COLORADO CENTRE METROPOLITAN DISTRICT ADMINISTRATIVE BUILDING - SITE DEVELOPMENT PLAN

PCD File No. PPR-21-51

EPC STORMWATER REVIEW COMMENTS
IN ORANGE BOXES WITH BLACK TEXT

GRADING & EROSION CONTROL PLAN

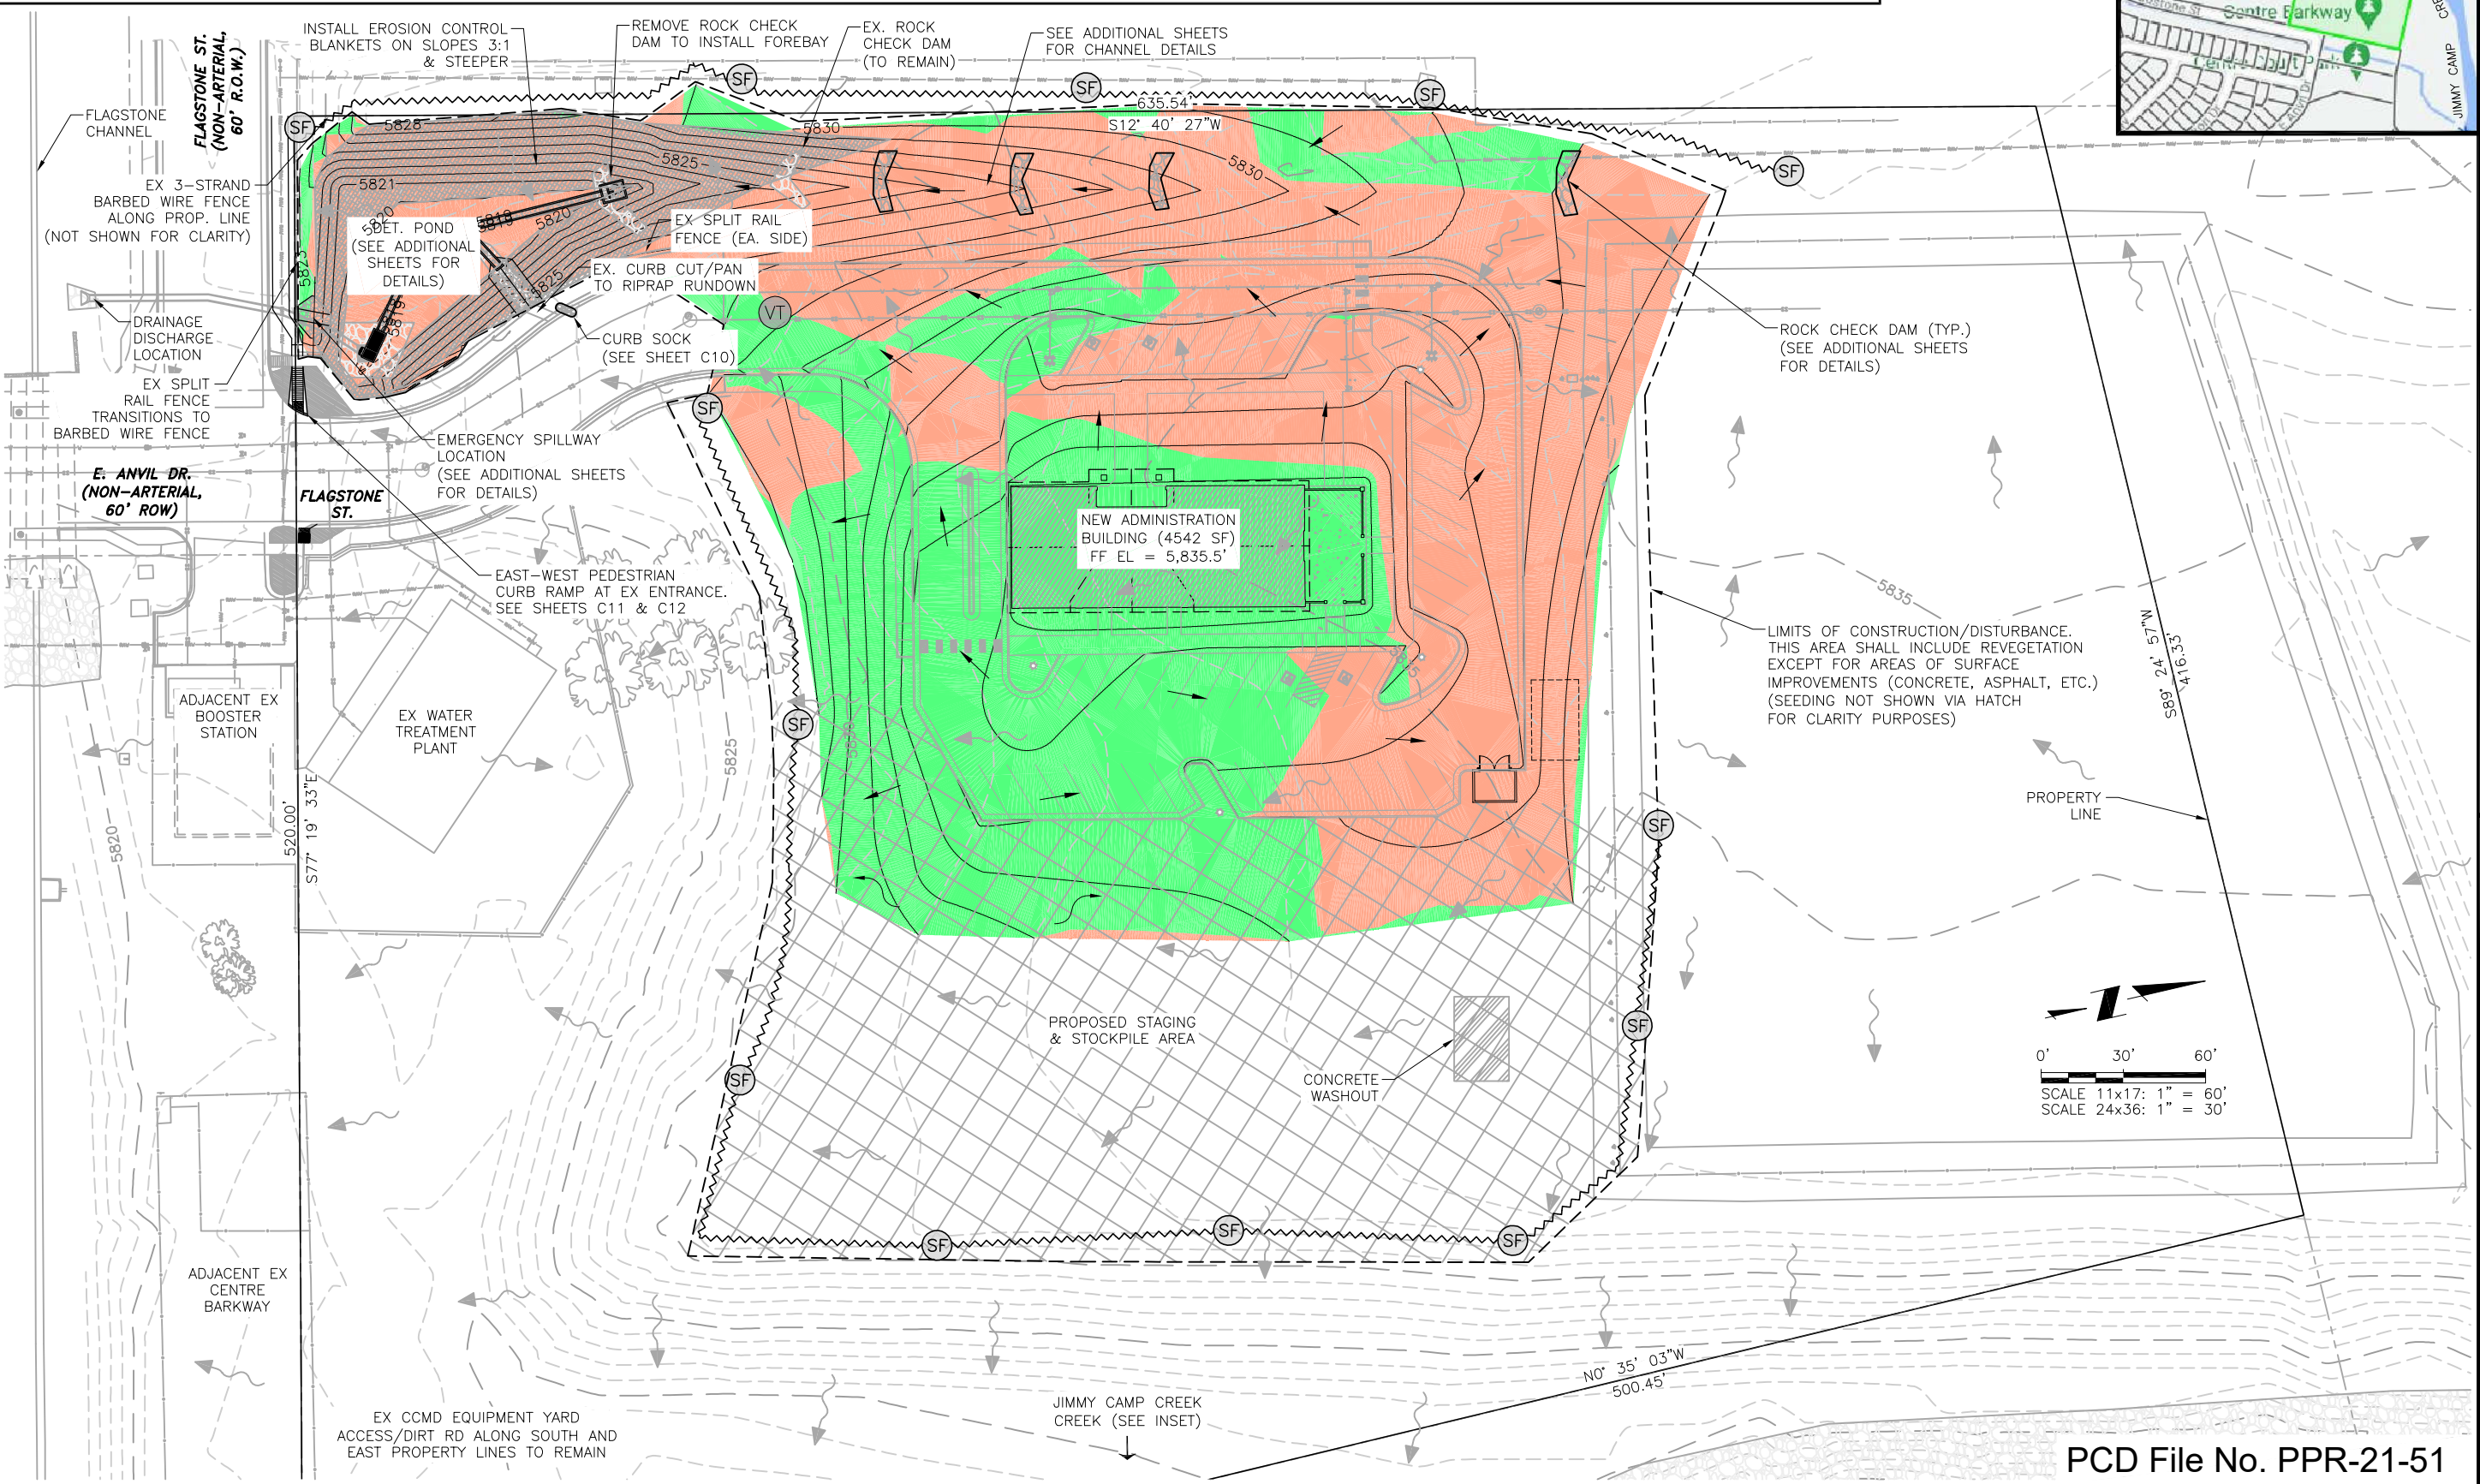
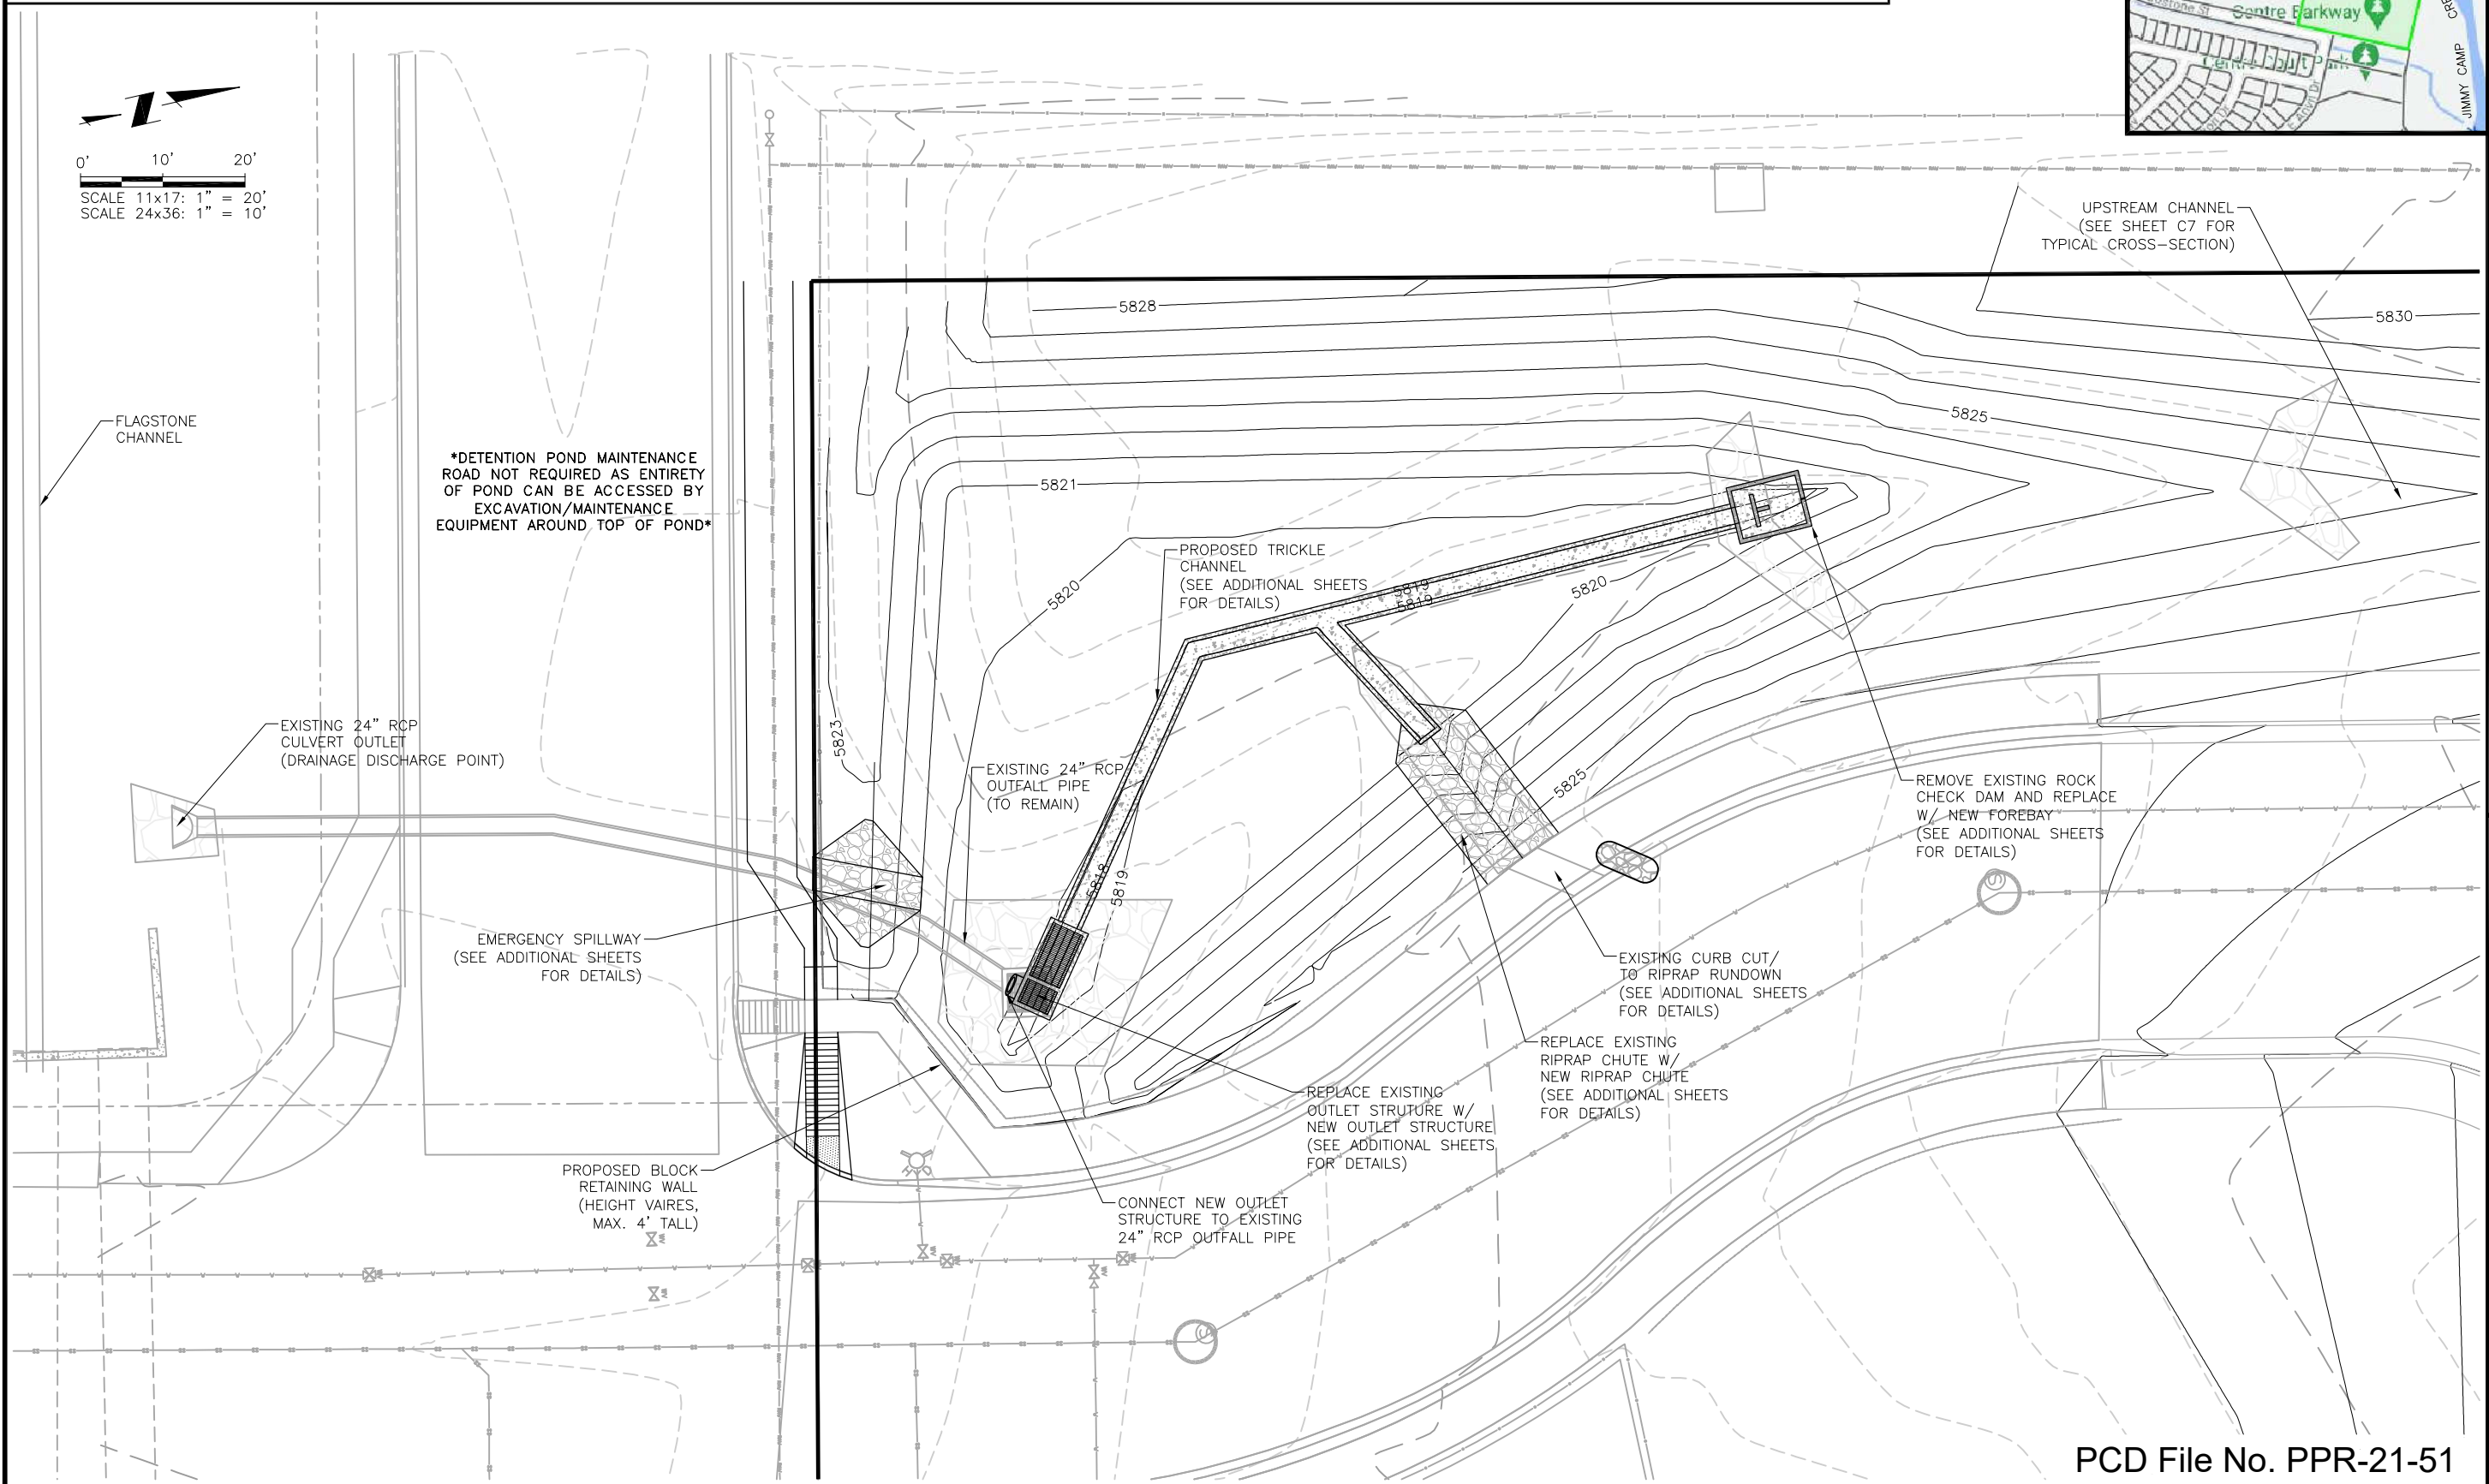
label all pond components and include pond details, location of tie in, ultimate discharge location, outfall protection, maintenance road, riprap type and gradation, etc.

add to legend: curb sock (interim)

provide detail for trapezoidal channel in accordance with drainage report
